**WA/63/21**

I object to this application and make these comments in relation to the technical note added November 2021 in which there are numerous errors.

**Technical note – page numbers refer to the pdf numbering**

Plate 4.2 – Departure Routing to the West

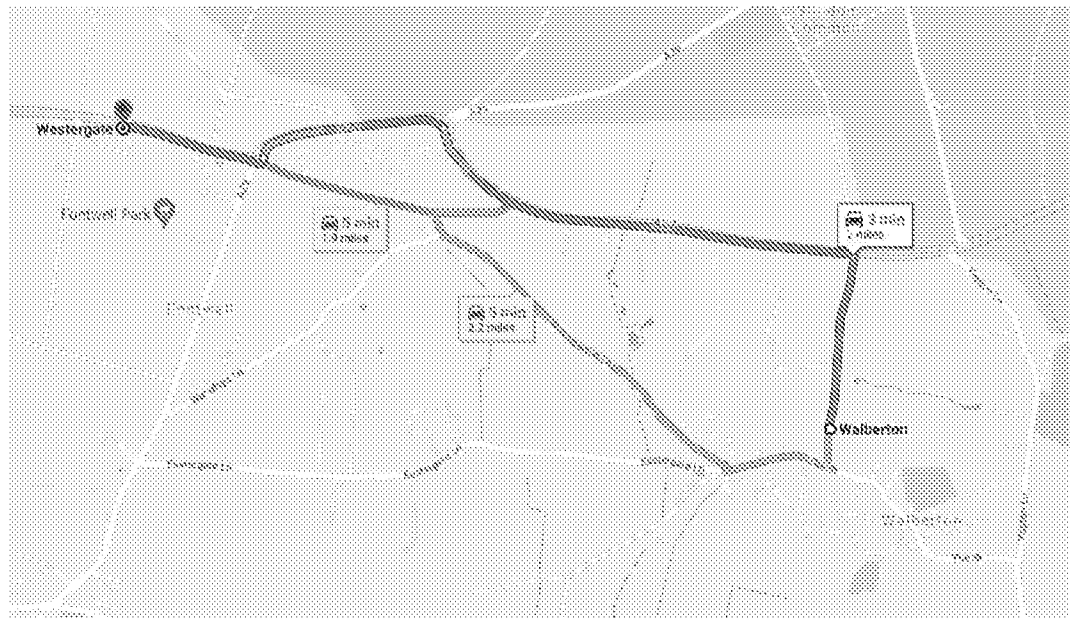
States "Vehicles departing the site are more likely to make use of the A 27 to the north as this offers journey time / distance savings'

This will **not** be the case if the A27 bypass Grey route proceeds.

VIEWPORT 1 - PROPOSED RESIDENTIAL ACCESS AT TYE LANE

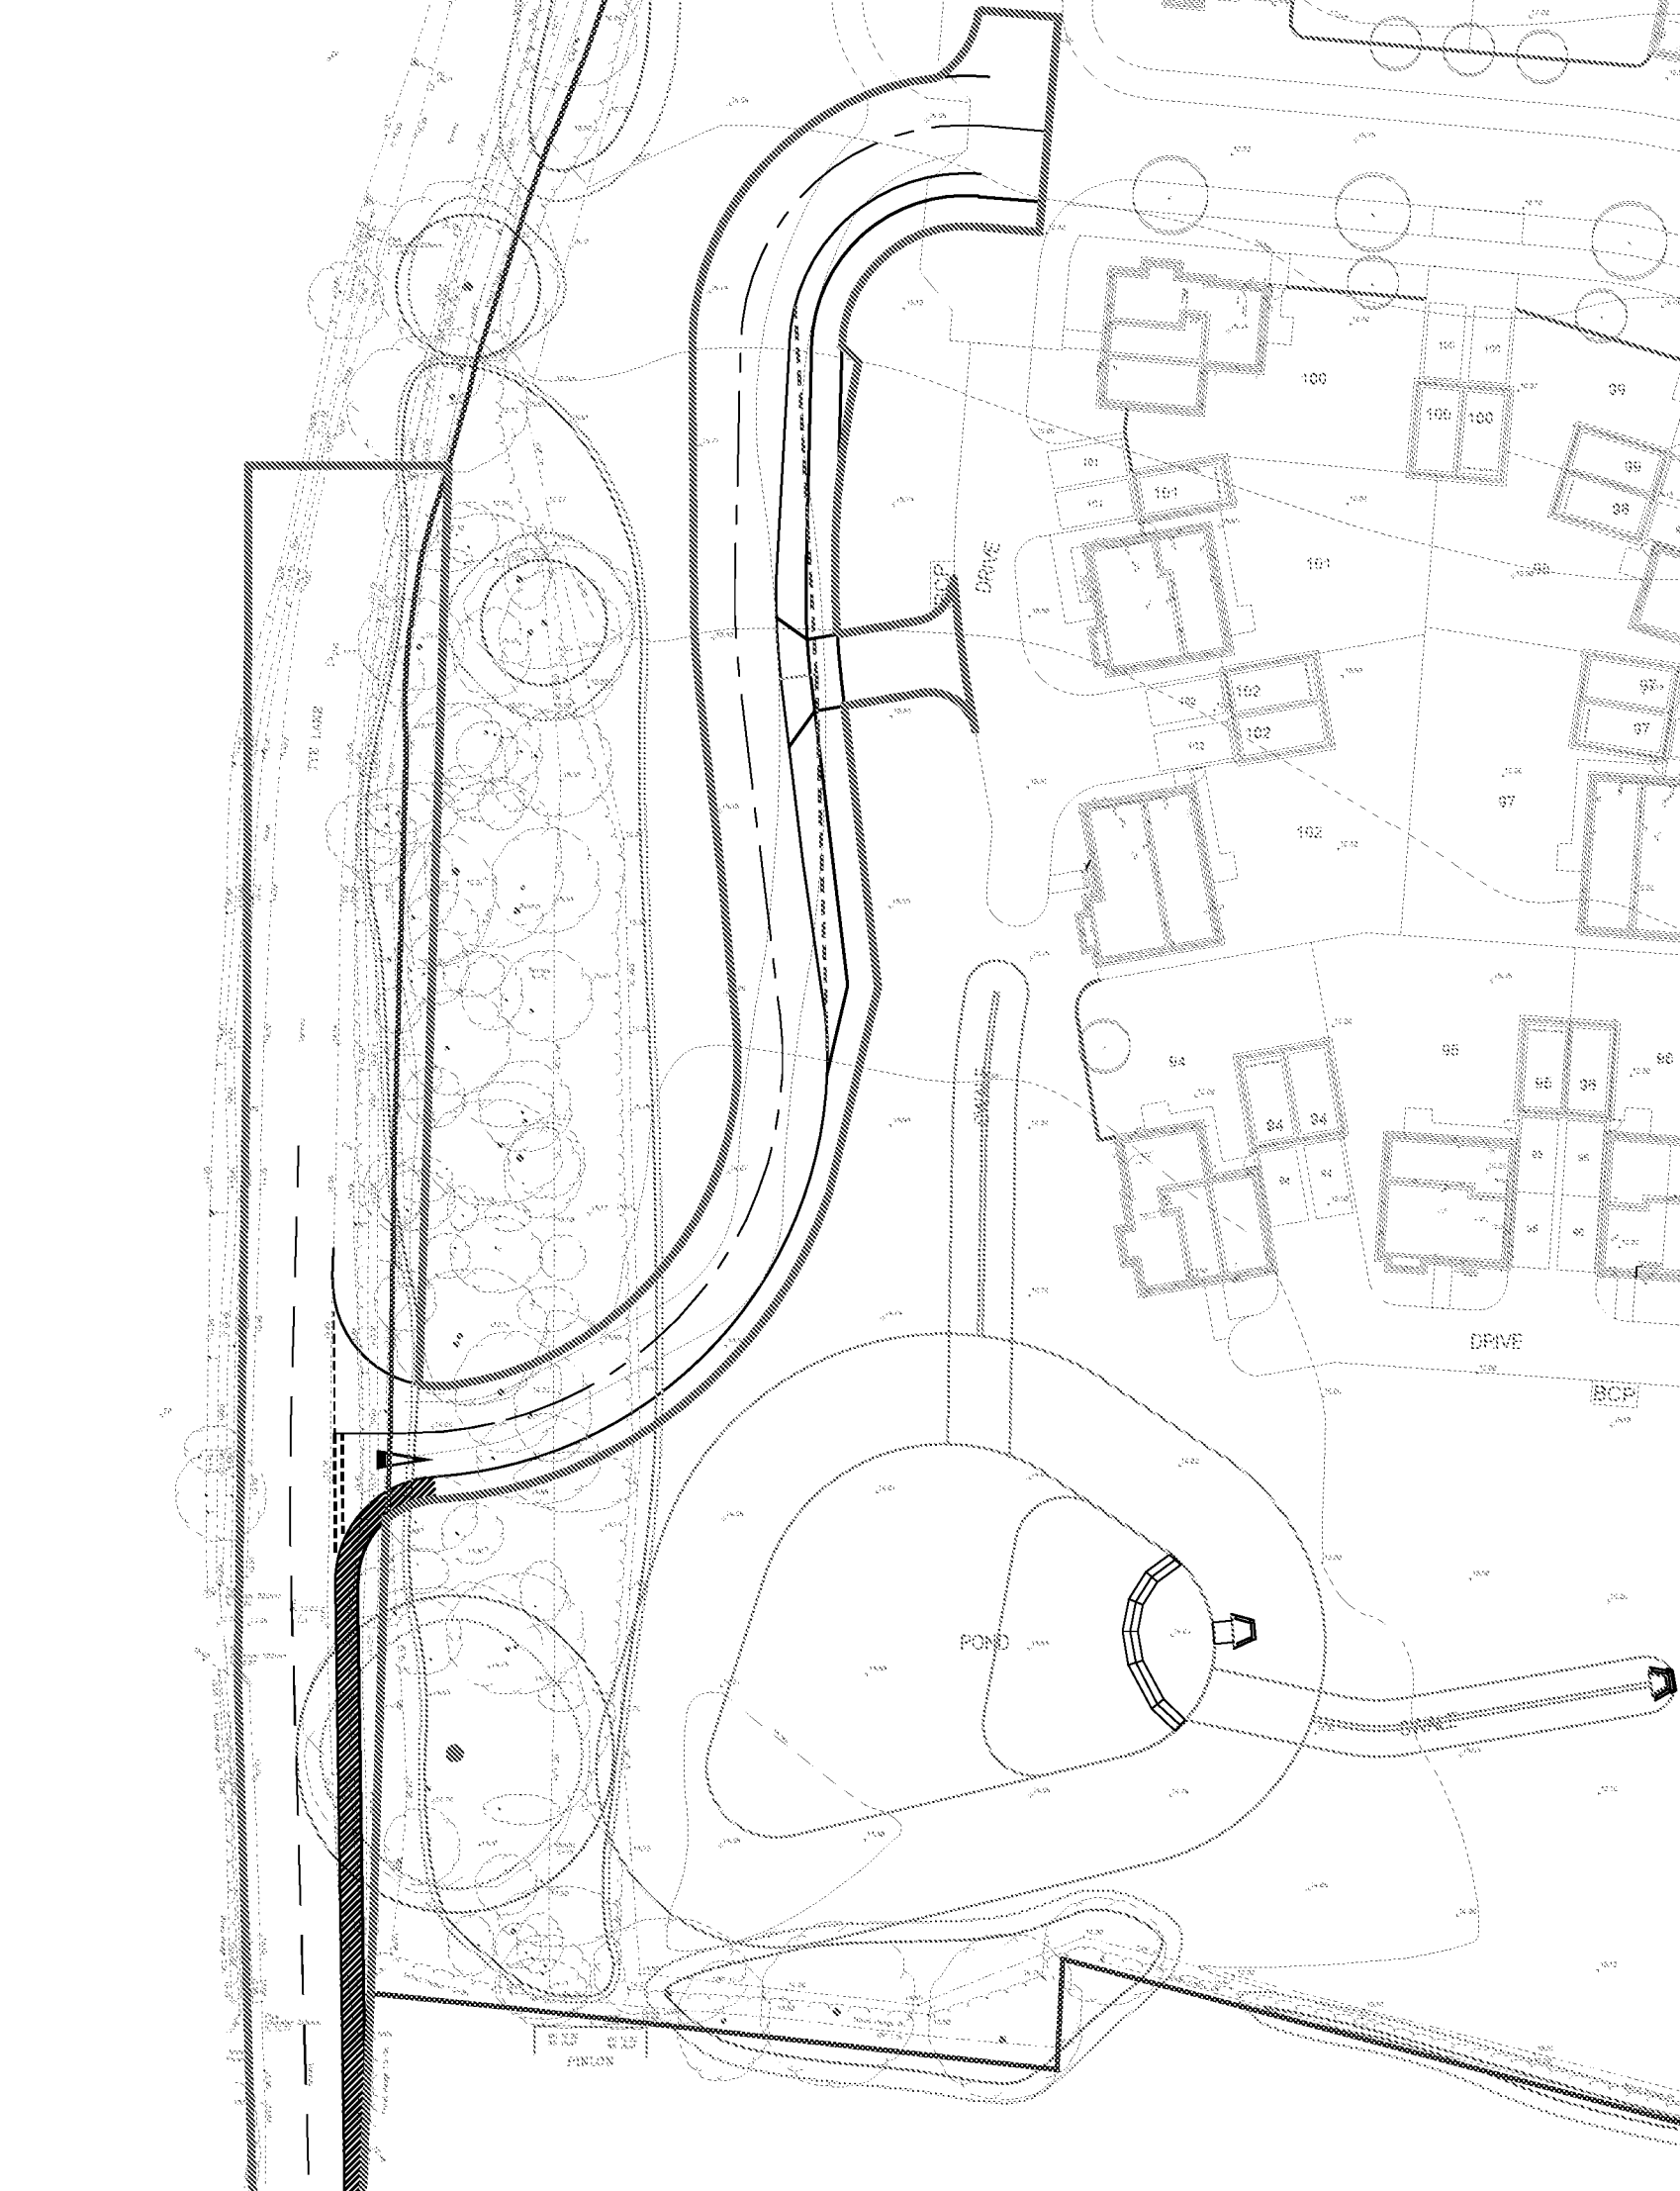
Yapton Lane is between 6.1 m and 7m wide and has a footpath on one side. Tye Lane is approximately 4.8 wide along much of its length... and is to have a footpath added thereby reducing the carriageway width.

***NOTE - The current access is from a 7m carriageway, and this proposed access from a 5 m carriageway (Drawing no: 183248-002 – Page 94)***
